Department of Planning, Housing and Infrastructure

Our ref: Wagga Wagga Lithium-Ion Battery Recycling Facility

Subject: **Request for Additional Information - SSD-67983064**

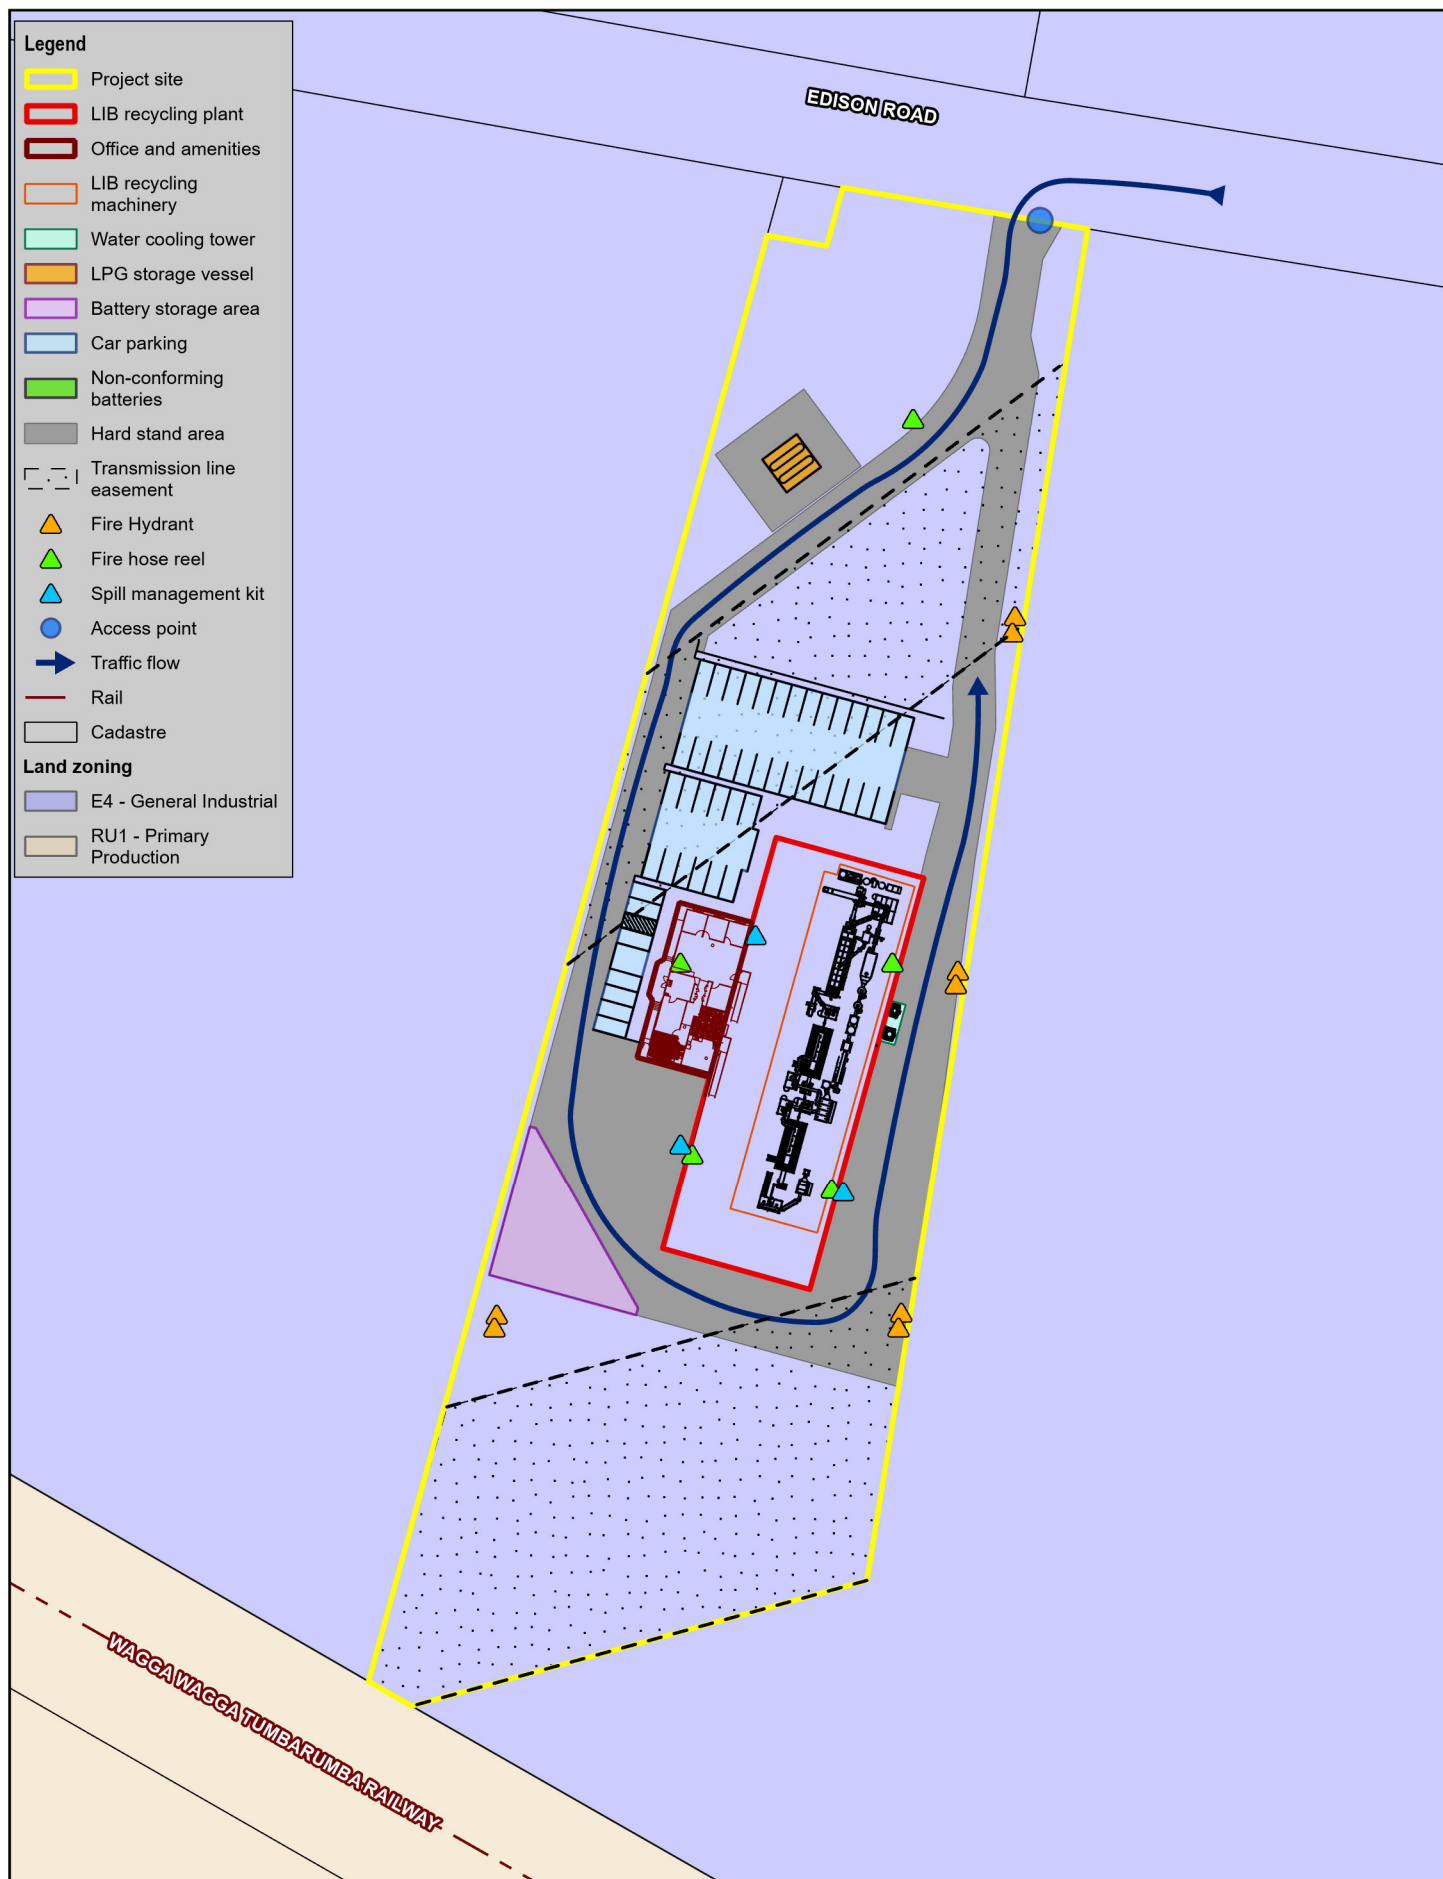
- all fire containment / management systems and any water tanks dedicated for firefighting (including showing the location on a site plan)
- employee training, emergency procedures and robust risk assessment processes
- how the site will provide safe, efficient and effective fire brigade access in accordance with the 'FRNSW Access for Fire Brigade Vehicles and Firefighter' guidelines
- storage containment, treatment and disposal of waste firewater
- FRNSW has advised that waste facilities present special problems of fighting fire. Please demonstrate that the development will comply with the NCC, including details of any performance solution prepared in consultation with FRNSW.
